Rezoning Transportation Analysis

Petition Number: 2023-035

From: Jake Carpenter, PE
Jacob.carpenter@charlottenc.gov
980-221-5675

Date	Description
7-26-23	First Review (PM)
8-23-23	Second Review (PDM)
9-27-23	Third Review (JP)

**RZ-1**  
Sheet 1 of 2

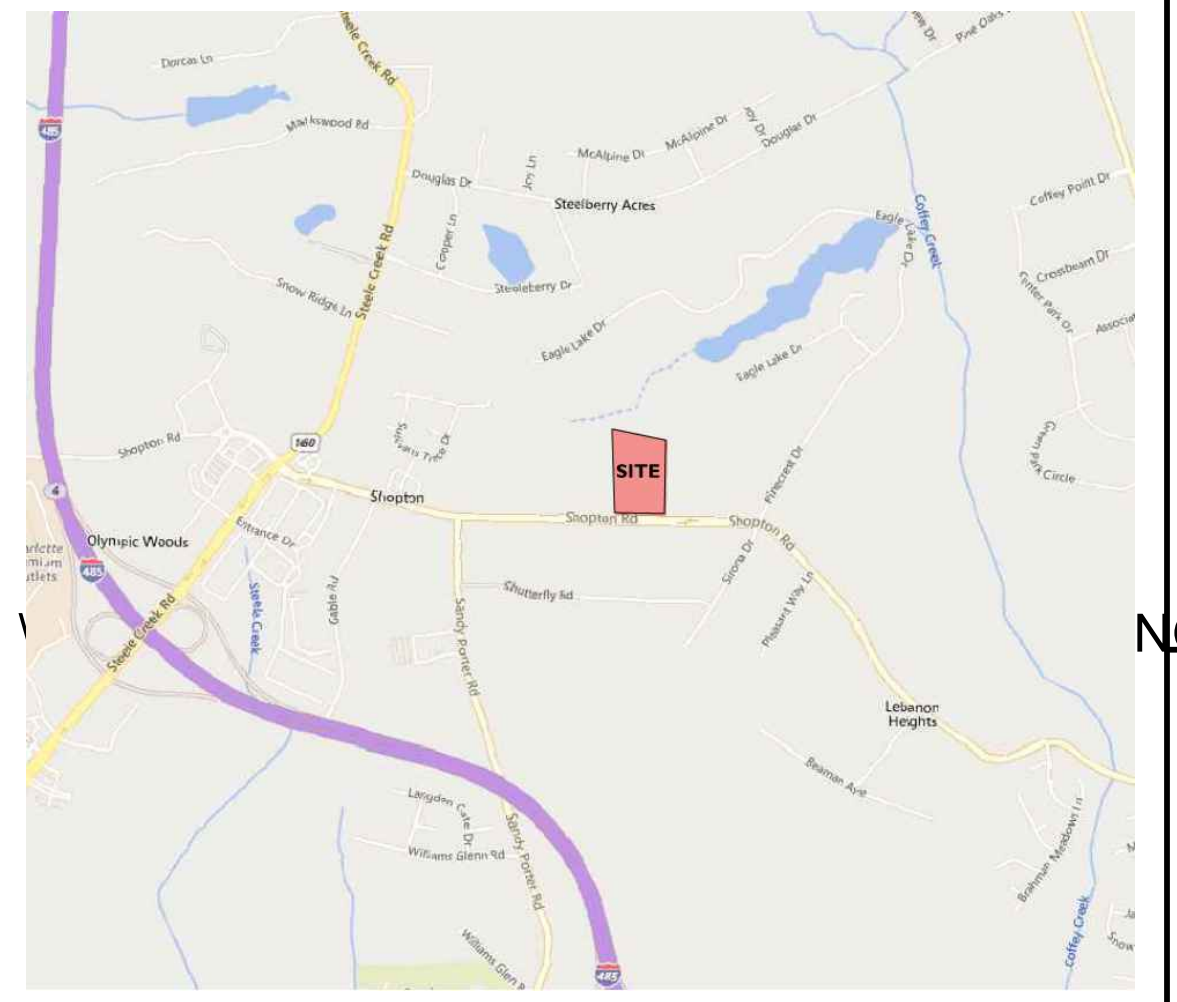
7. Per coordination with NCDOT, revise site plan and conditional note(s) to commit to installing a left turn lane into the site from Shopton Road.
~~Clarifying Comment: Show left turn lane or two-way left turn lane on site plan.~~

9. **New Comment 9.27.23:** Revise site plan to remove truck apron and widen driveway to accommodate appropriate turning movements. Add conditional note for driveway design to be finalized during permitting as approved by CDOT/NCDOT.
